116 Beech Street

Urban Design Review Panel Report

RESPONSE TO UDRP RECOMMENDATIONS SITE PLAN APPLICATION FOR 116 BEECH STREET

Date: 3 February 2026
Application No: N/A
Project: 116 Beech Street

NORTH & EAST ELEVATIONS

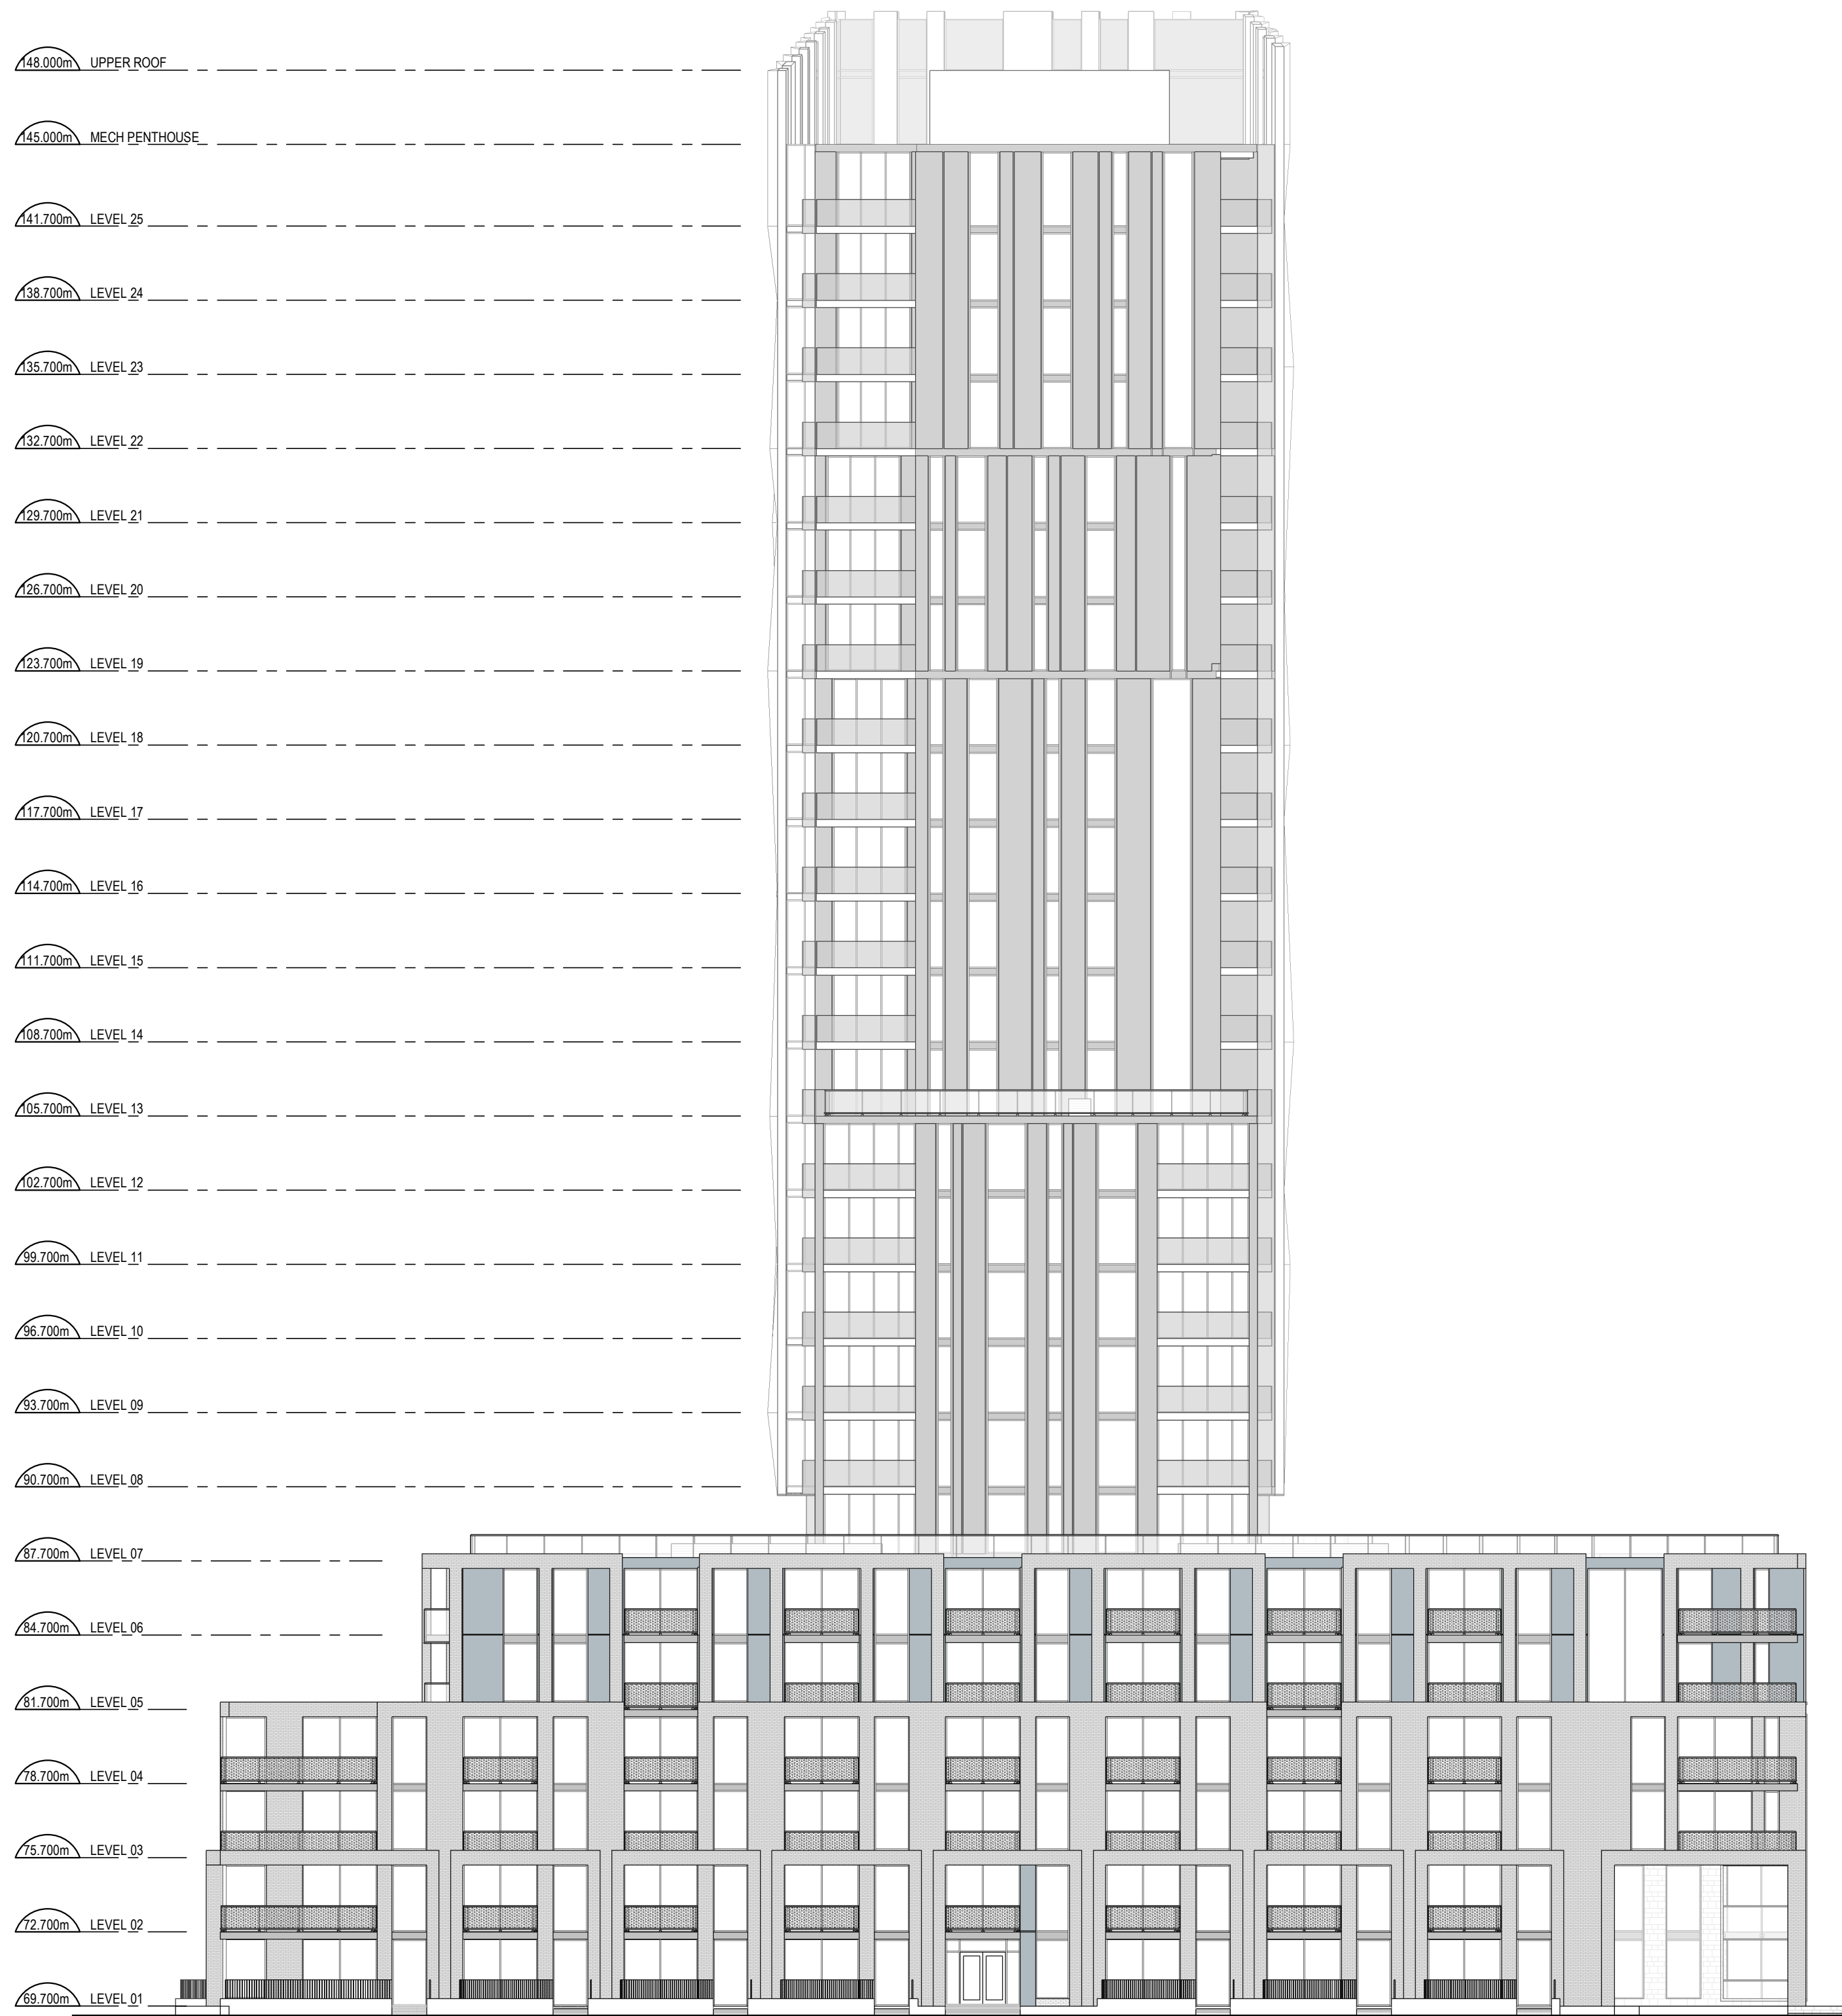
- The Panel recommends removing the “bump out” (levels 7 to 12) along the Loretta Avenue elevation.
Noted.
- The Panel recommends forgoing the contrasting dual treatments in the tower’s architectural expression and suggests wrapping the lighter ribbon expression around all sides of the tower.
We strongly disagree. The tower articulation is metaphorical to the duality of the nature of the abutting streets to the east and west. These are highly contrasting urban contexts that are being mitigated through the design of this building.

- Some Panel members suggested building on the “notching” at the northwest corner of the podium and continuing that approach along the Loretta Avenue podium façade, in combination with reducing the podium height along Loretta Avenue to 4-storeys. Consider those suggestions and explore other solutions that would assist with reducing the podium massing to be more respectful of the residential neighbourhood fabric across the street.
Noted, however we disagree with these panel members.

SOUTH & WEST ELEVATIONS

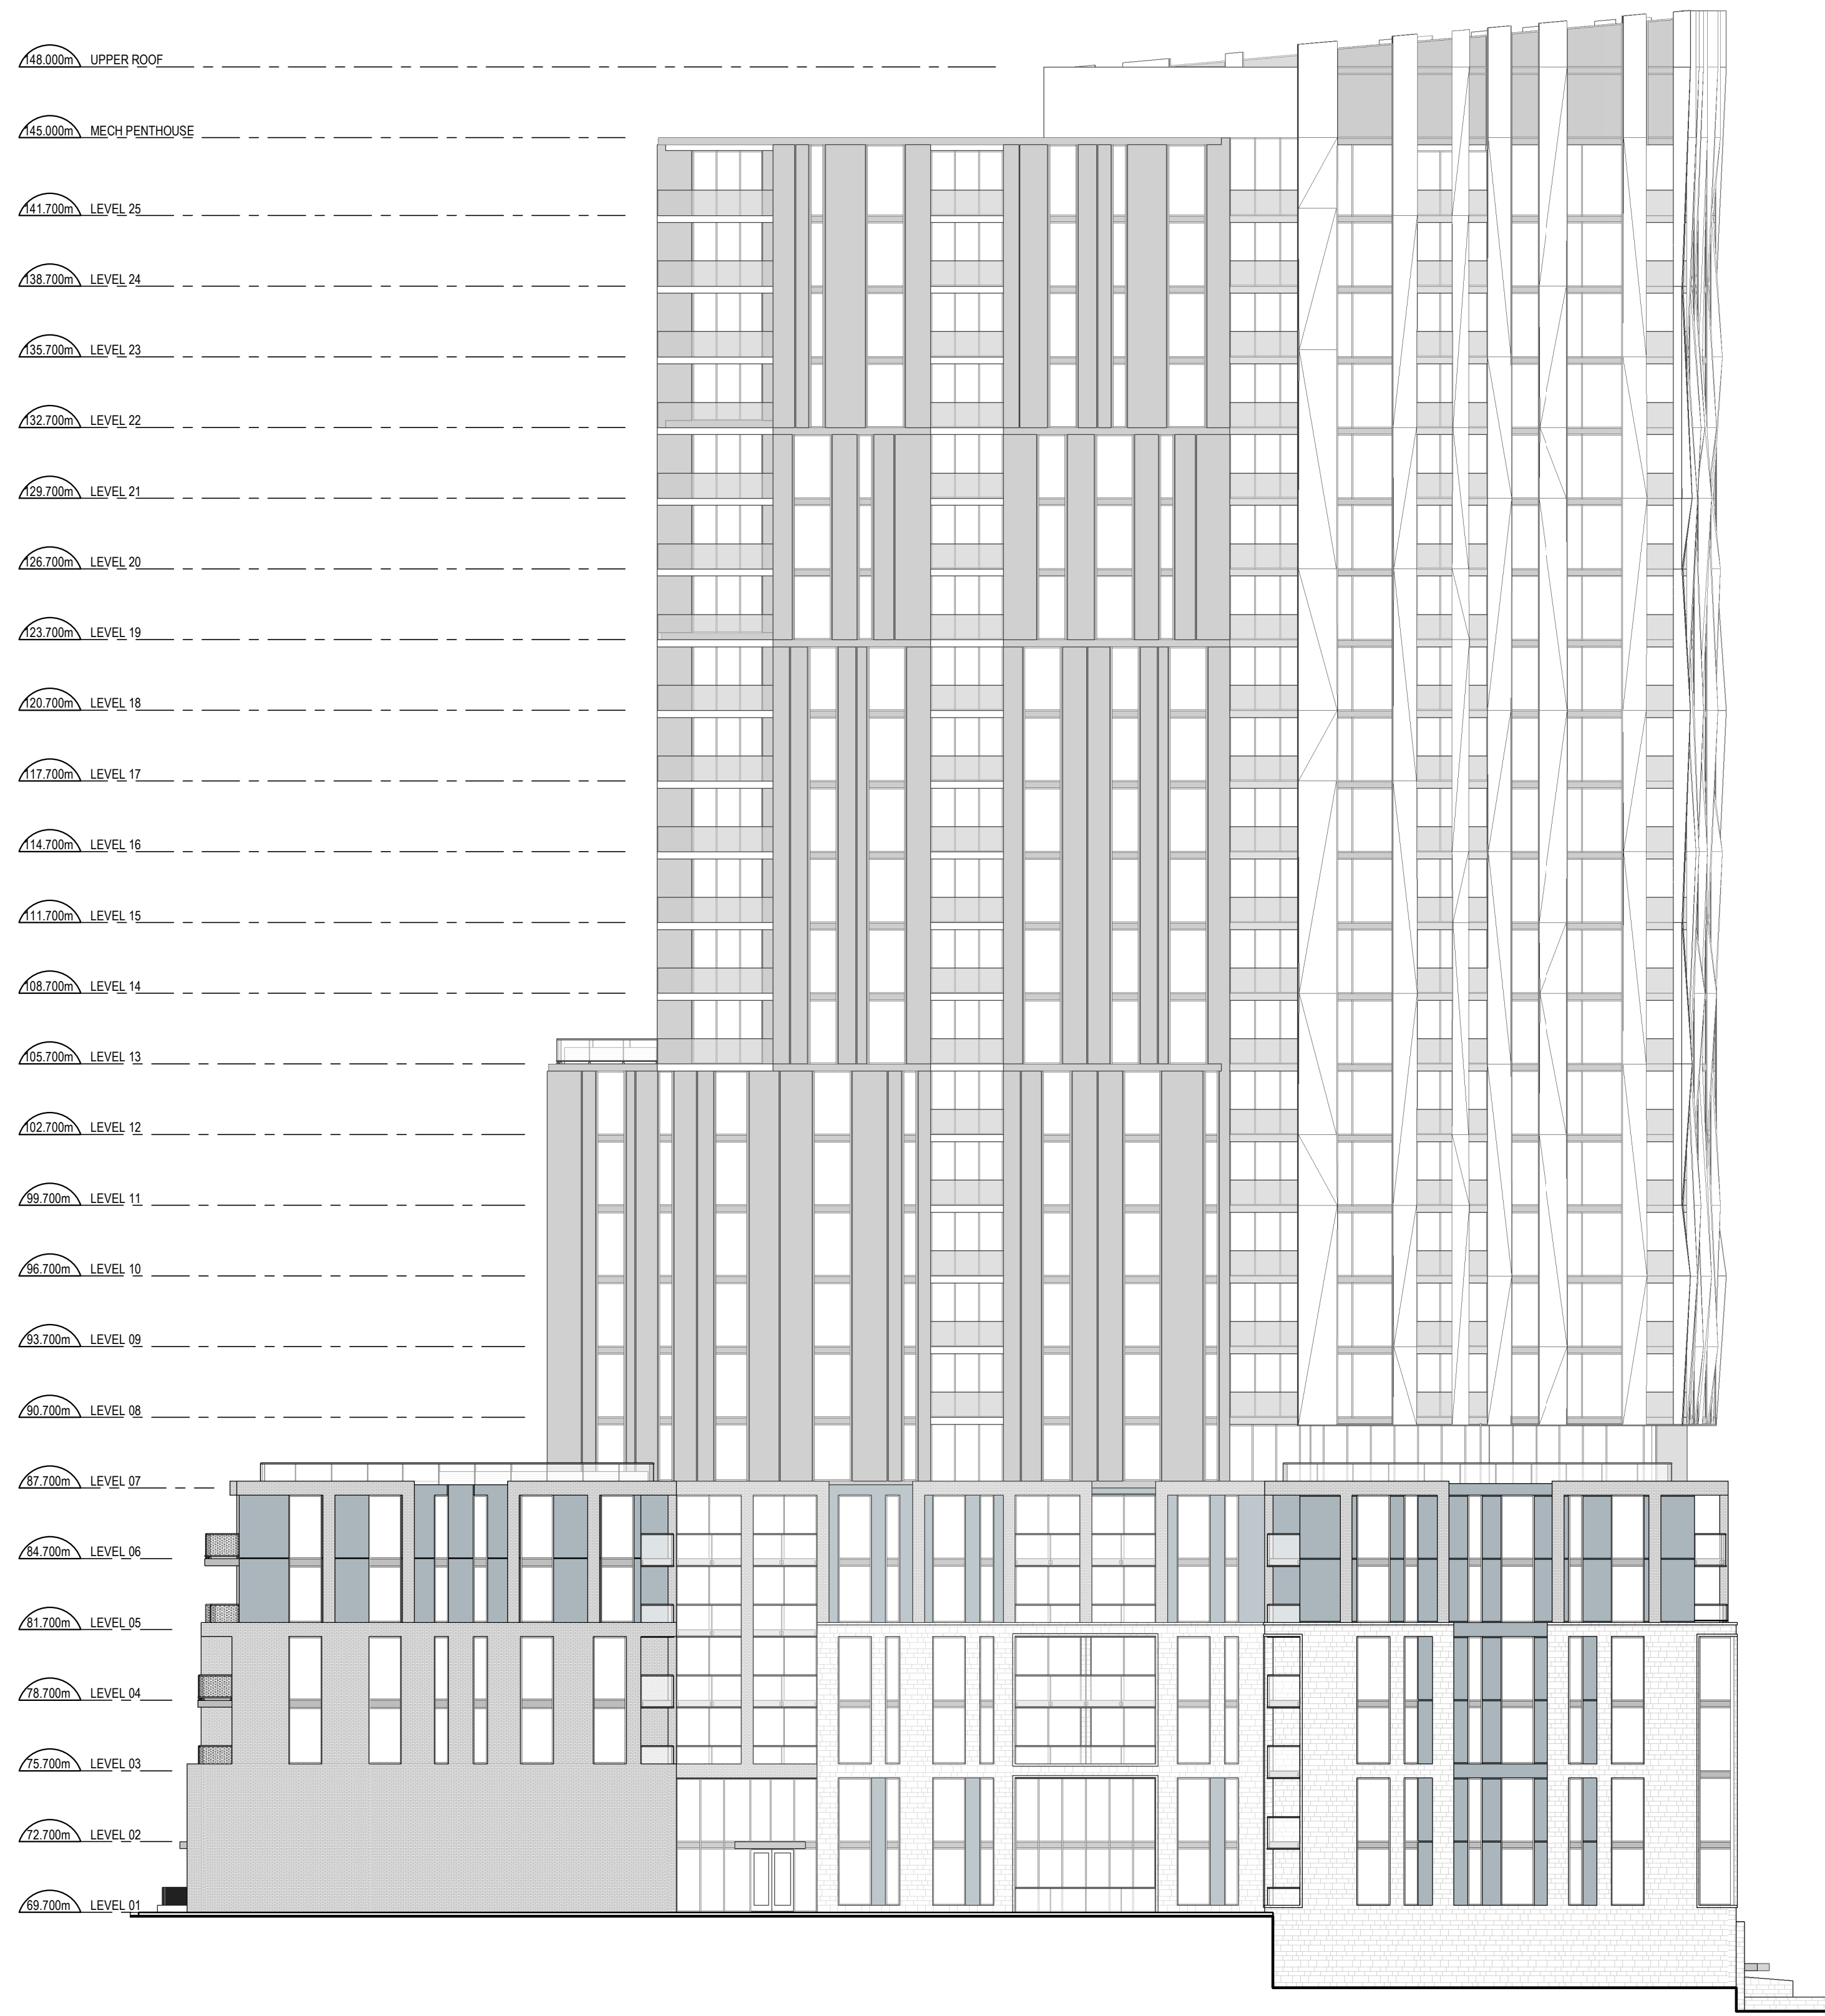
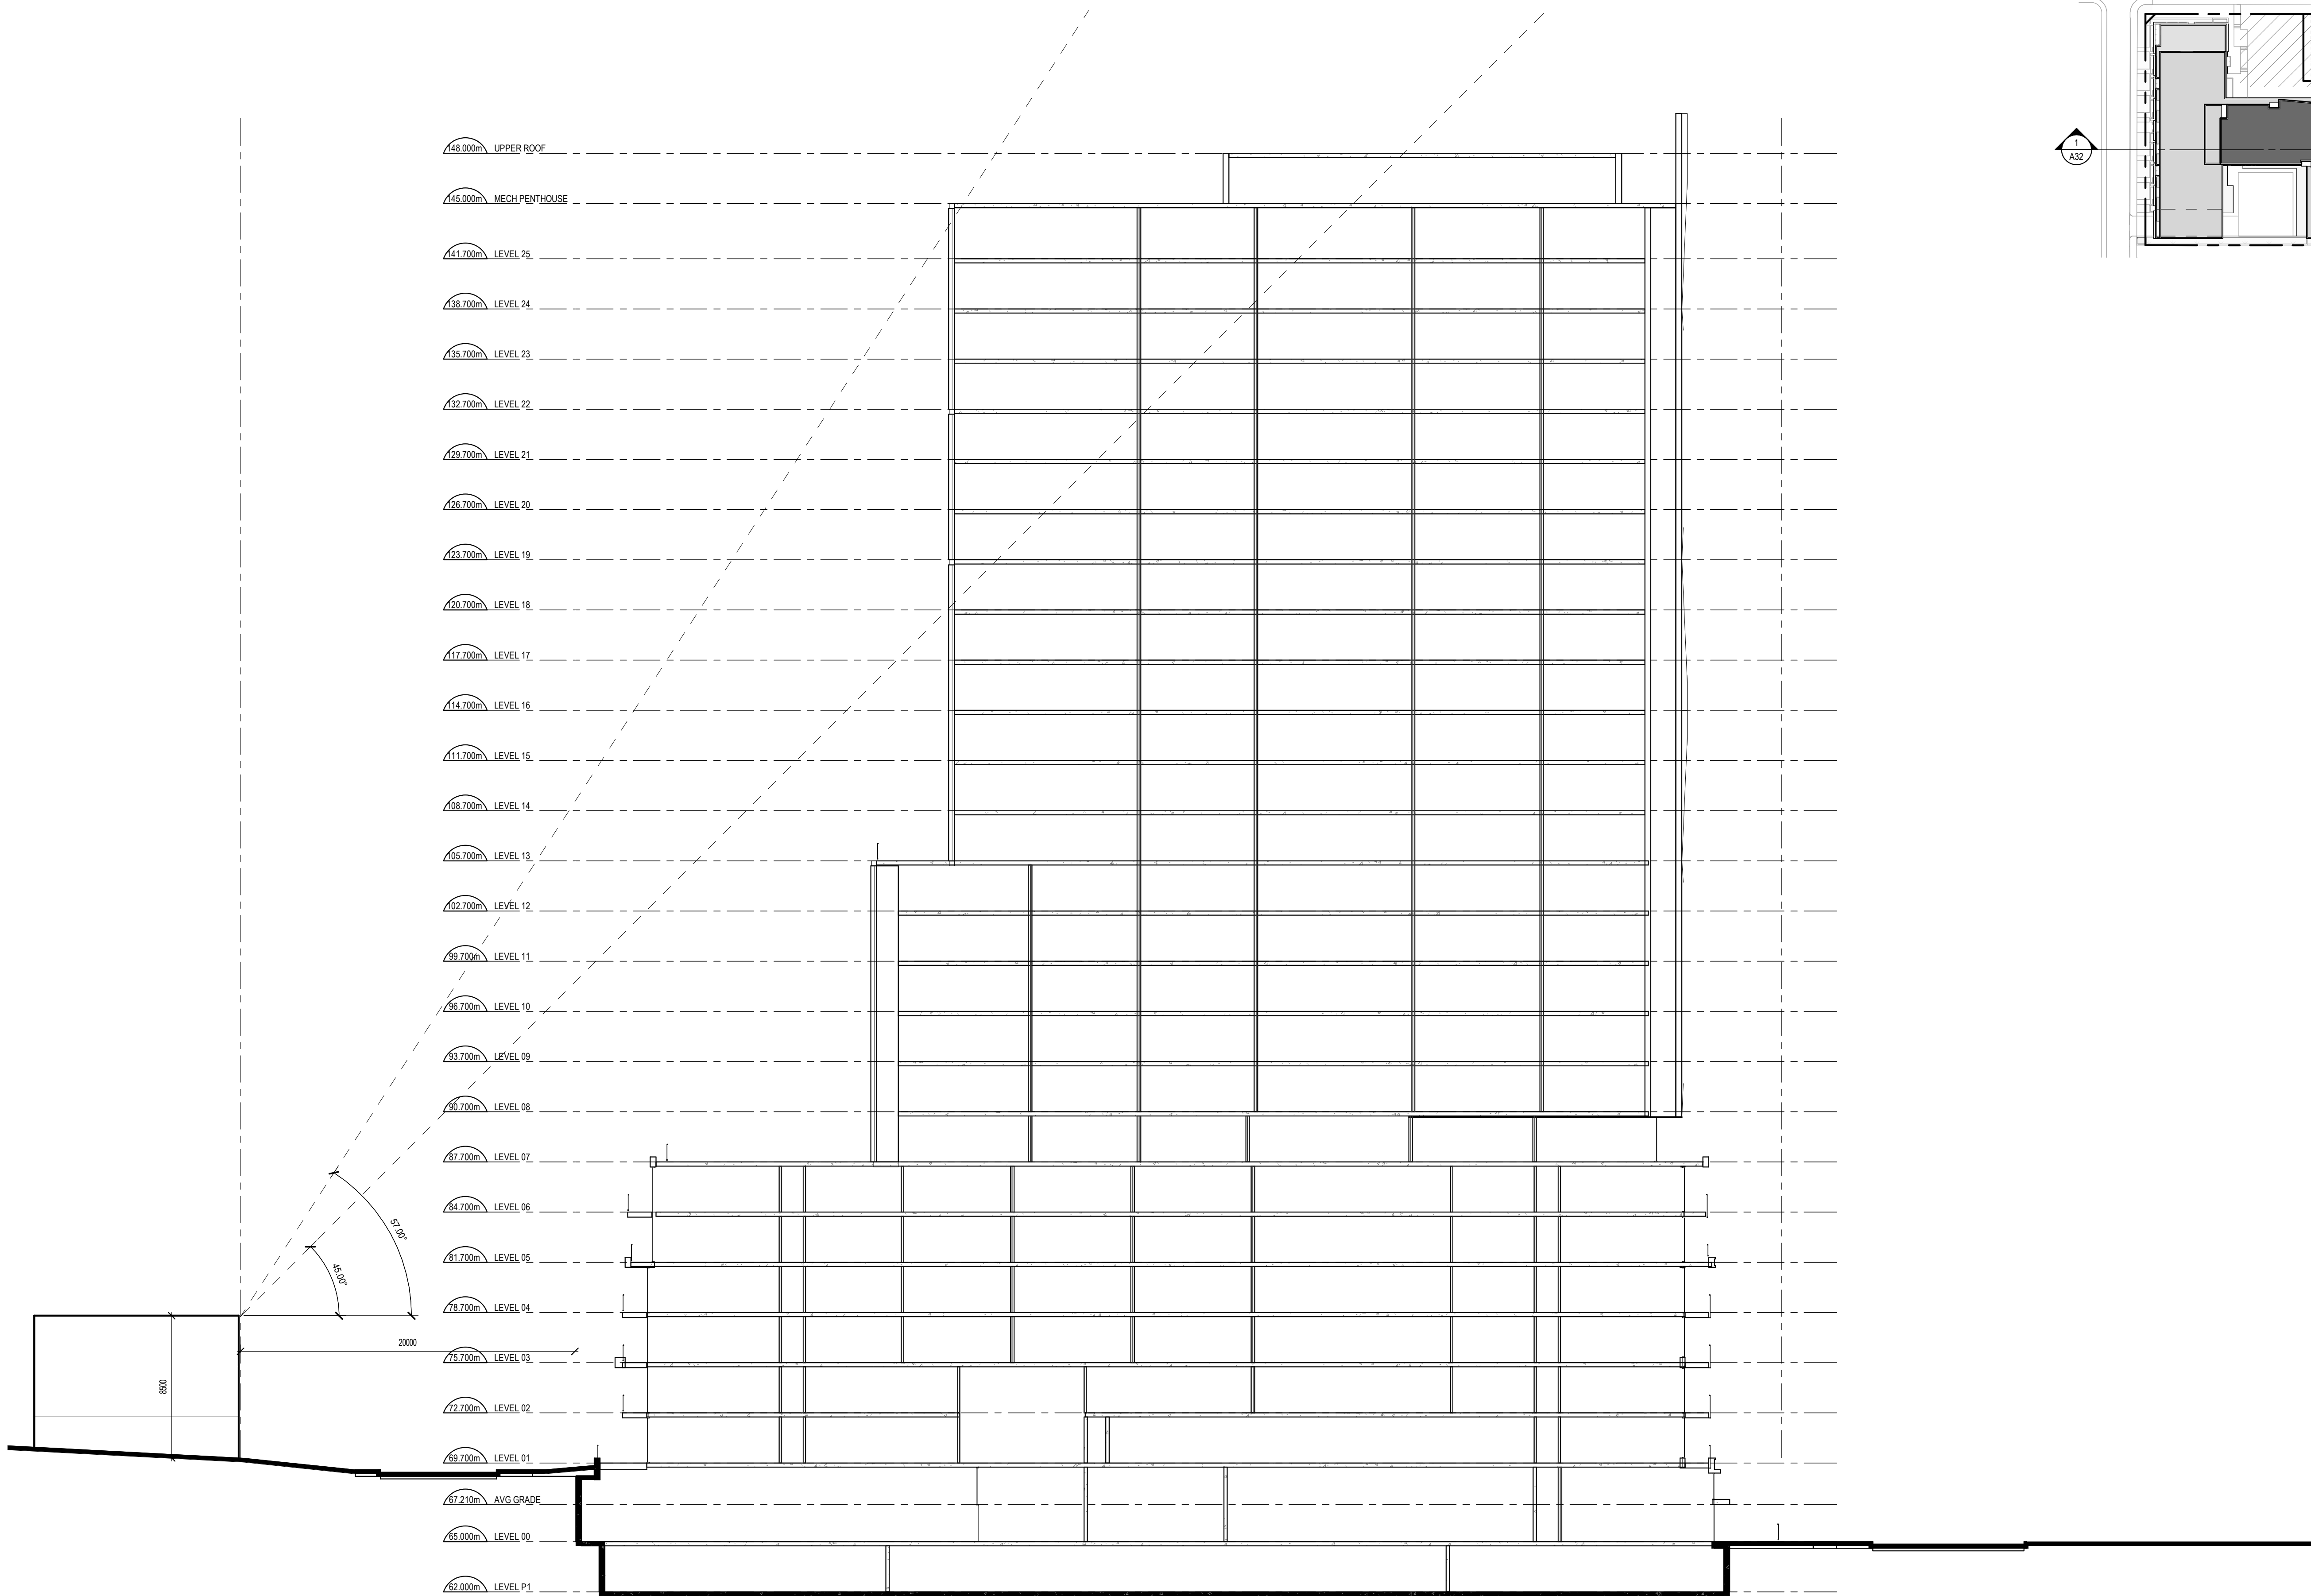
- The Panel appreciates the generous move of incorporating storage rooms into the floor plans.
Noted.
- The Panel has concerns with the “dark and ominous feeling” of the western portion of the building and suggests a lighter tone would appear less impactful.
We would encourage the panel to be more adventurous in reviewing colours and tones of proposed cladding materials.
